Subject: RE: Planning Consultation on A/113/19/DOC - Angmering site

Engineers Comments Regarding Condition 9- surface water drainage design

APPLICATION NO: A/113/19/DOC

Site Address: Crete Nursery Dappers Lane Angmering BN16 4EN

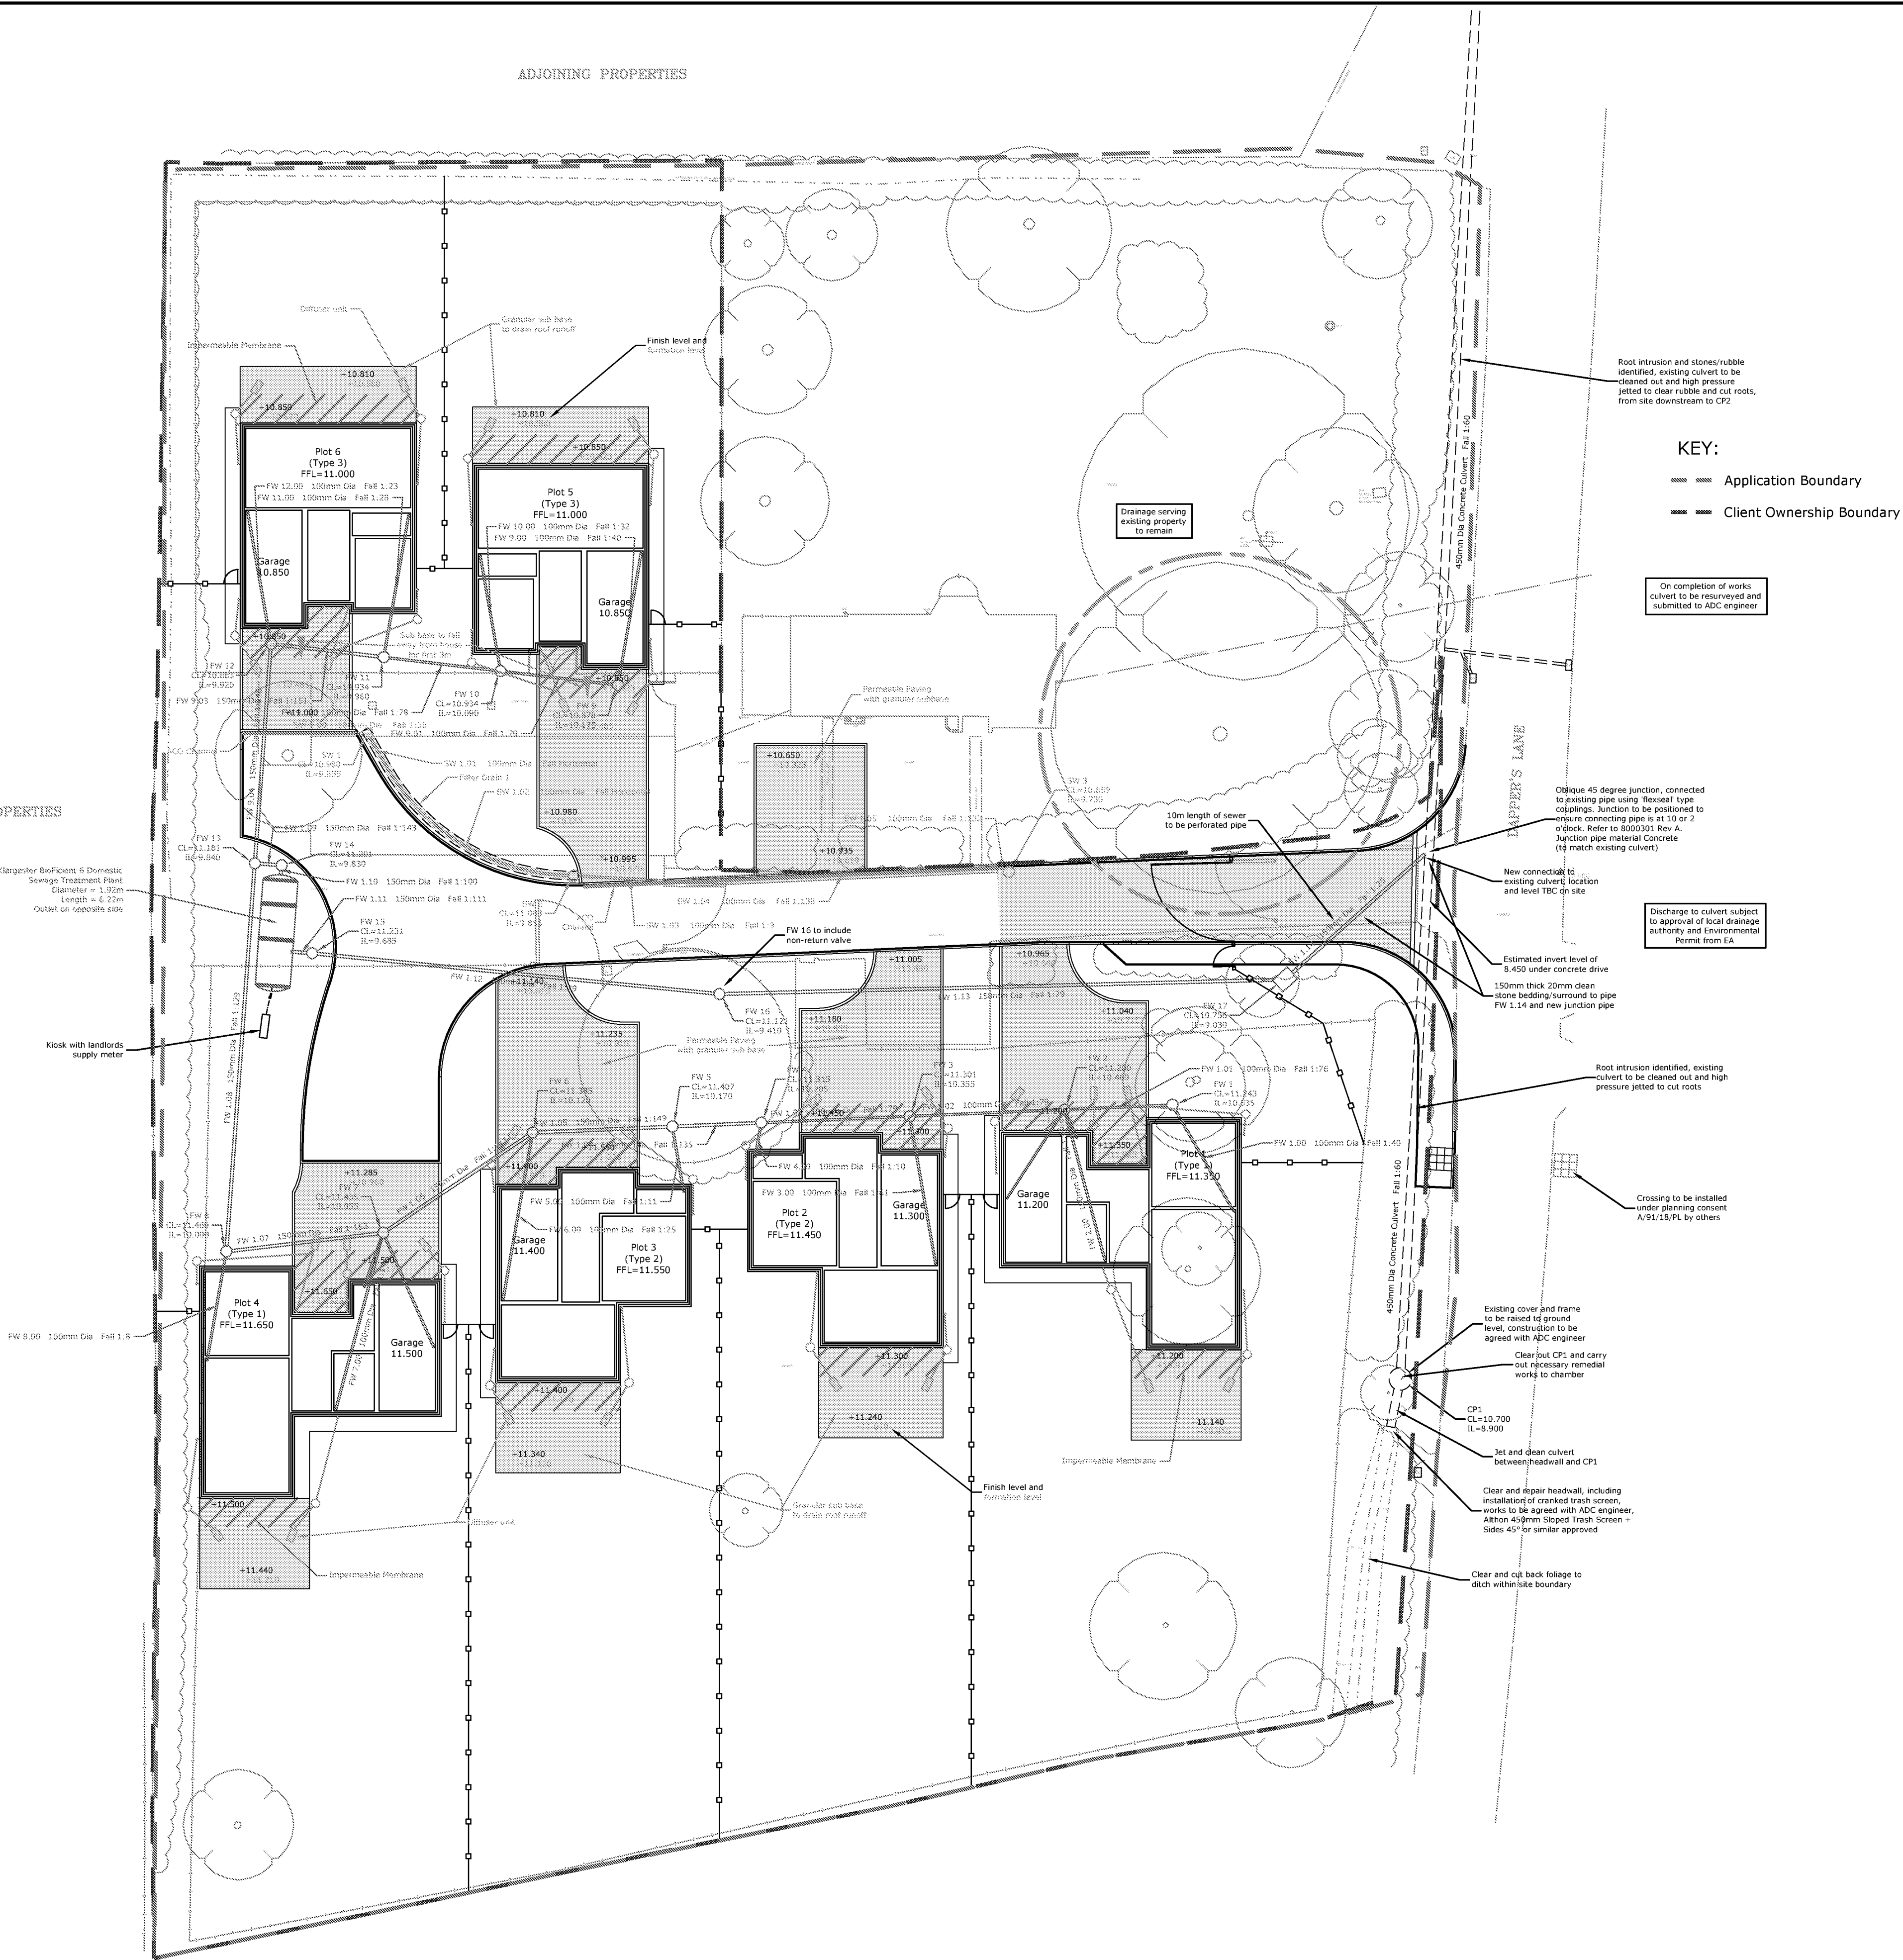
3. Please can an impermeable areas plan be provided that clearly shows the impermeable areas draining to each surface water drainage feature.
4. The filter drain is inadequate. Maximum modelled water depths are nearly 1m. This clearly will not be able to be contained above maximum recorded groundwater level.

7. A permeable liner should fully wrap around the sub-base of the permeable paving areas.
8. Please confirm material specification for filter drain. All sub-base material should be no fines.

9. Are diffusers to be used to disperse surface water into permeable paving subbases? Please provide construction details and locations of these if so. Diffusers should be located 5m from buildings, therefore the use of permeable patios to receive roof water is not acceptable.

3. Please can an impermeable areas plan be provided that clearly shows the impermeable areas draining to each surface water drainage feature. Please refer to enclosed drawing 191183/SK/04 for impermeable areas. *This will likely need to be revised due to comment 9 below.*

7. A permeable liner should fully wrap around the sub-base of the permeable paving areas. Please refer to drawing 191183/SD/01. *Okay.*
8. Please confirm material specification for filter drain. All sub-base material should be no fines. Please refer to drawing 191183/SD/01. *Type 3 is not permeable.*

9. Are diffusers to be used to disperse surface water into permeable paving subbases? Please provide construction details and locations of these if so. Diffusers should be located 5m from buildings, therefore the use of permeable patios to receive roof water is not acceptable. Diffusers have been added to the drawing. The patios have an impermeable surface so that rainwater runs off onto the grass and the subbase is only infiltrating the roof runoff. *As stated, diffusers should not be located within 5m of buildings. Permeable structures adjacent to buildings can receive water falling directly upon them, but should not receive concentrated rainwater within 5m of buildings.*

191183/510/01

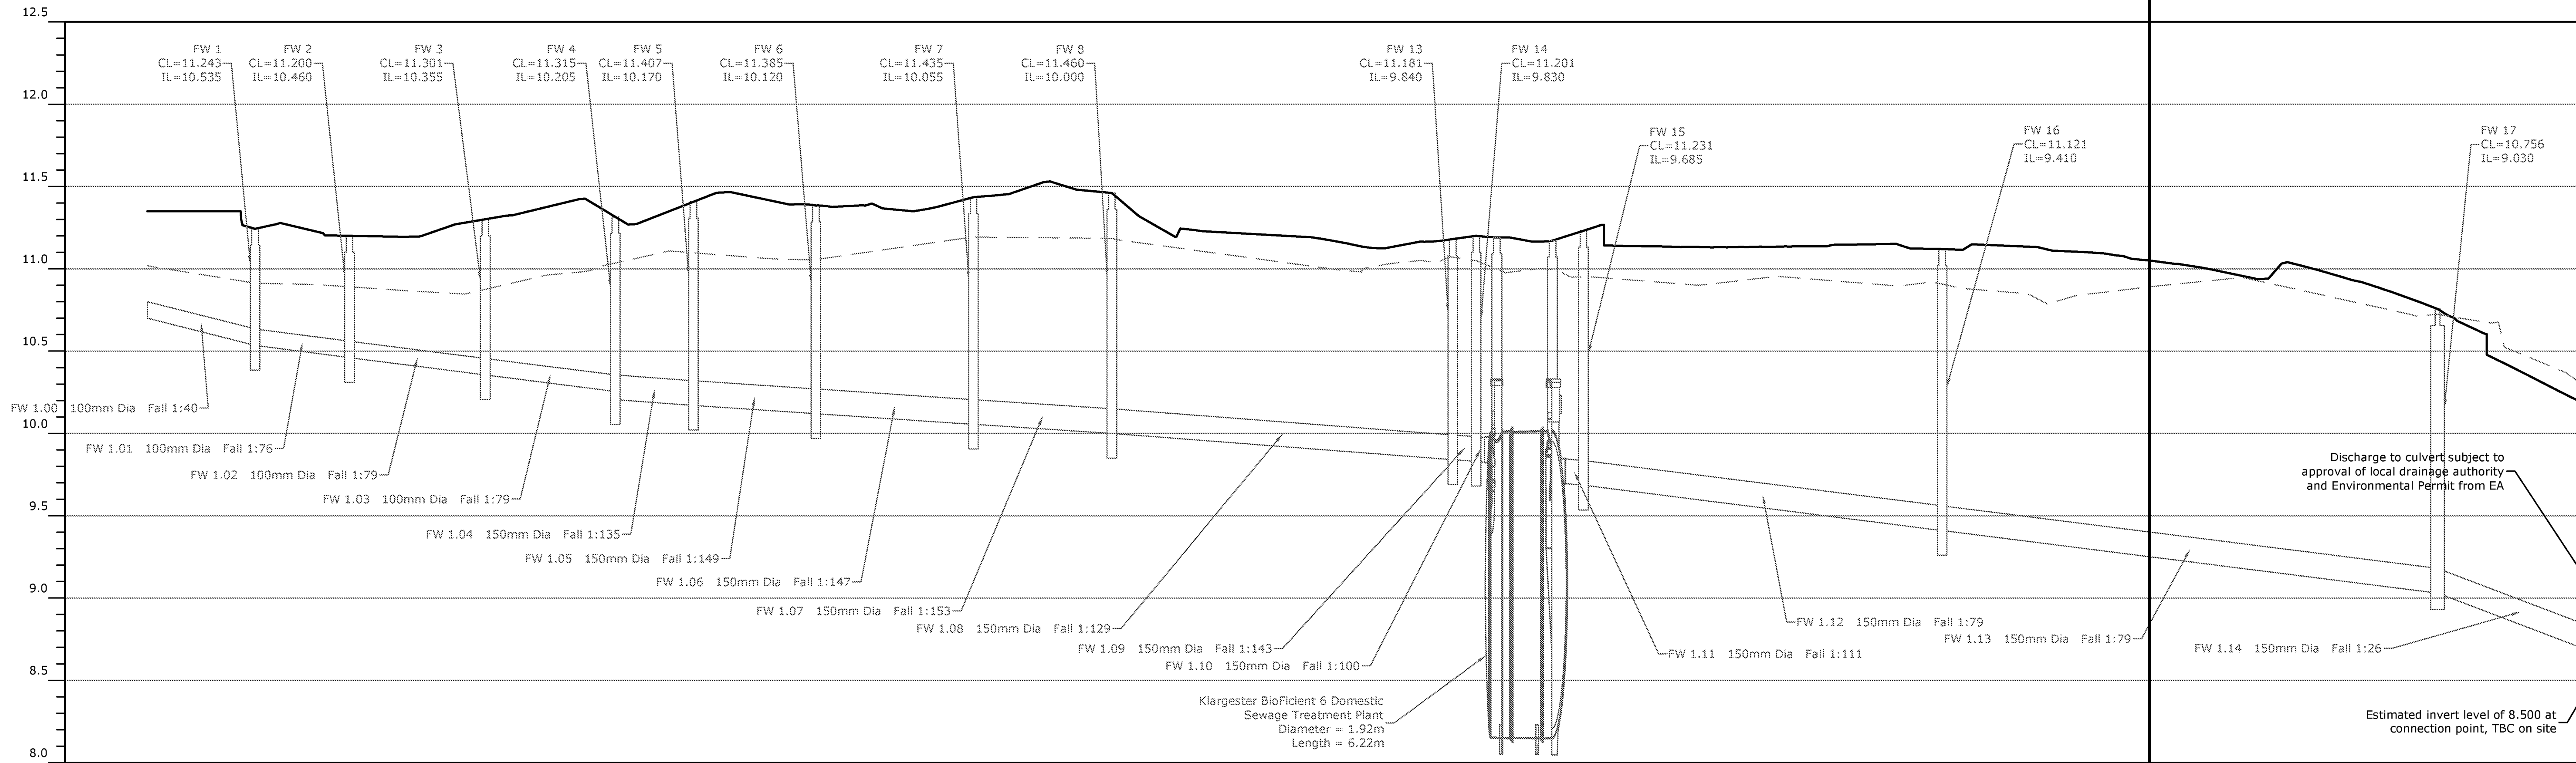
10. Catchpits must be provided upstream of all connections to permeable paving. Please ensure the location of rwp, catchpits, and connections to permeable areas are clearly shown on plan.

11. Please provide invert levels and cover levels of all inspection chambers, manholes, filter drains, etc. Please also ensure that finish and formation level of permeable paving is clearly provided on plan.

11. Please provide invert levels and cover levels of all inspection chambers, manholes, filter drains, etc. Please also ensure that finish and formation level of permeable paving is clearly provided on plan. Please refer to drawing 191183/500/01. *I will review further once GW and infiltration testing result acceptability has been agreed.*
